WEST SUSSEX COUNTY COUNCIL CONSULTATION

TO:	Arun District Council FAO: Maria Tomalova
FROM:	WSCC - Highways Authority
DATE:	4 September 2019
LOCATION:	Land off Canal Mews, Barnham, PO22 0AB
SUBJECT:	BN/66/19/PL Erection of 3 No dwellings.
DATE OF SITE VISIT:	N/A
RECOMMENDATION:	Advice
S106 CONTRIBUTION TOTAL:	N/A

Proposed Site Masterplan

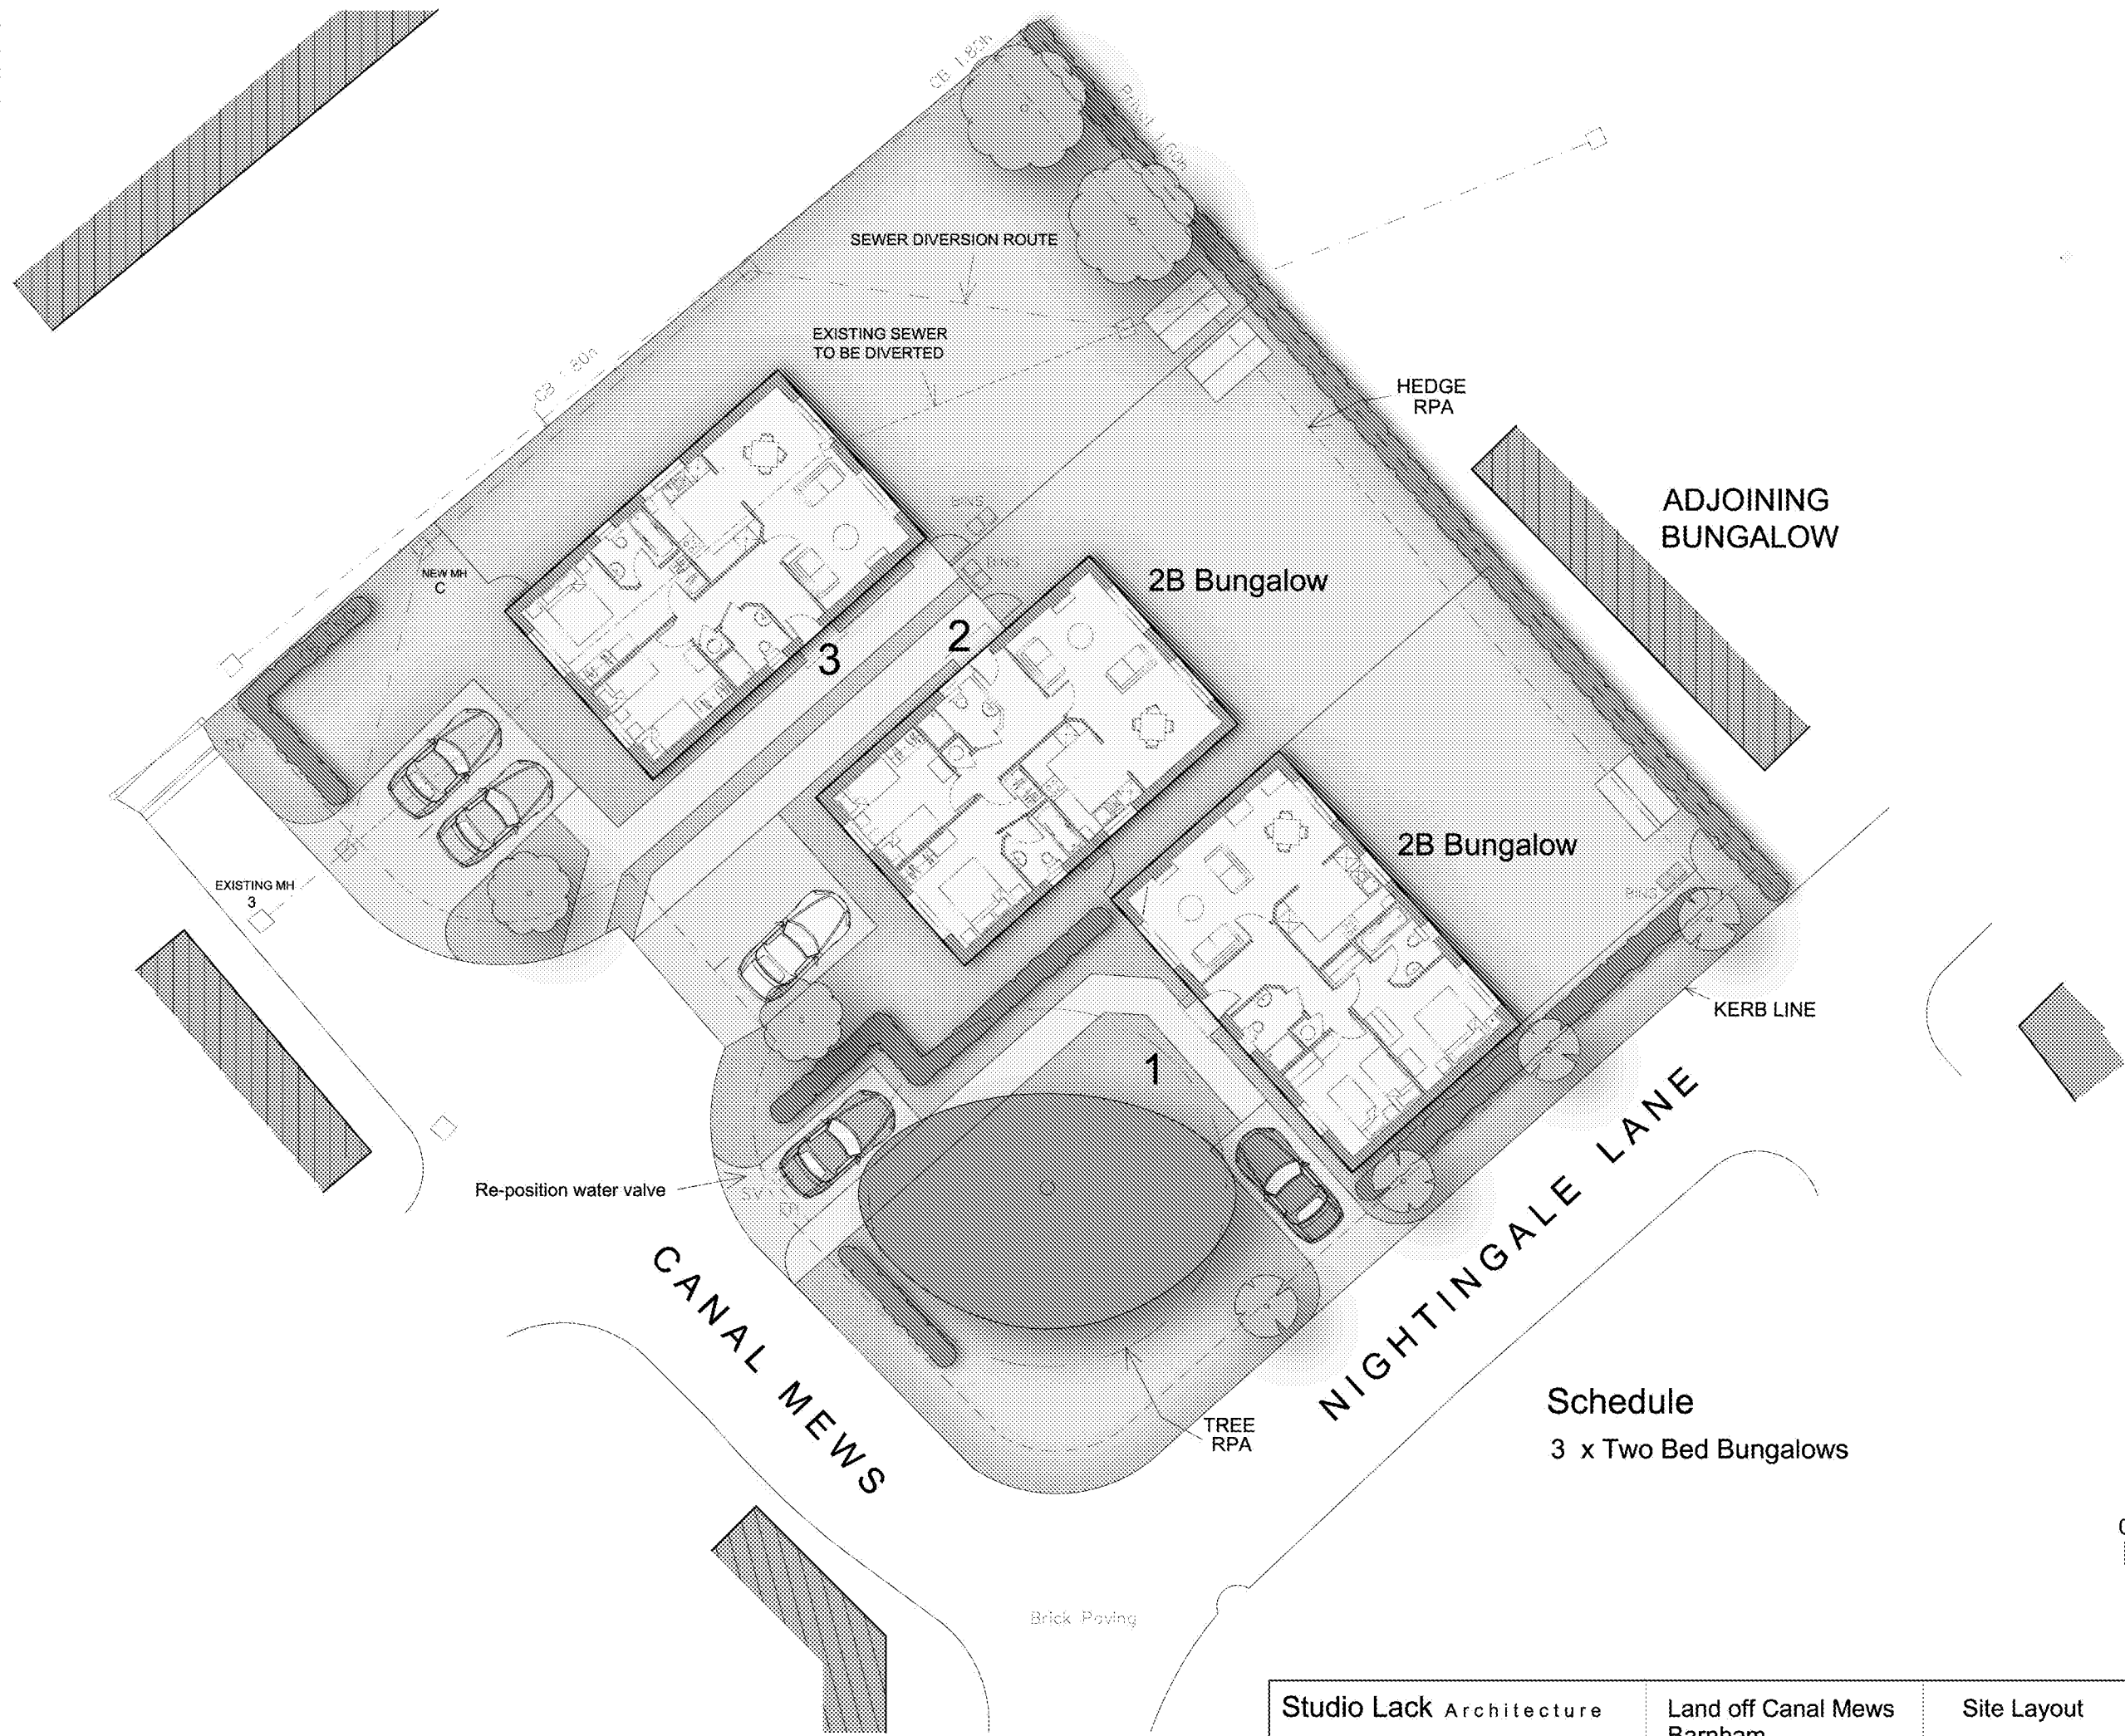
Plot 1 will be served by two accesses, one off Canal Mews and one off Nightingale Lane. Plots 2 and 3 will each have their own access off of Canal Mews. The applicant is advised to contact the proprietors of Canal Mews and Nightingale Lane to obtain formal approval for the access works on the privately maintained roads.

Each plot will have 2 car parking spaces, totalling 6 for this development. The WSCC Car Parking Demand Calculator has indicated that a development of this size in this location would create a demand for 5 car parking spaces. Therefore the proposed parking provision is considered acceptable to meet its demand.

Each parking space meets the minimum specifications for single car bays of 2.4m x 4.8m as set out in Manual for Streets (MfS). On-site turning will not be achievable, so vehicles may have to exit the site in a reverse gear.

Cycling is a viable option in the area. It is unclear if cycle storage is proposed by the applicant. Each plot appears to have a garden shed which can be used for secure and covered cycle storage. The inclusion of cycle storage in the plans increases the sustainability of the site by offering alternative modes of transport to the private car.

No part of the development shall be first occupied until the car parking has been constructed in accordance with the approved site plan. These spaces shall thereafter be retained at all times for their designated purpose.

No part of the development shall be first occupied until covered and secure cycle parking spaces have been provided in accordance with plans and details submitted to and approved by the Local Planning Authority.
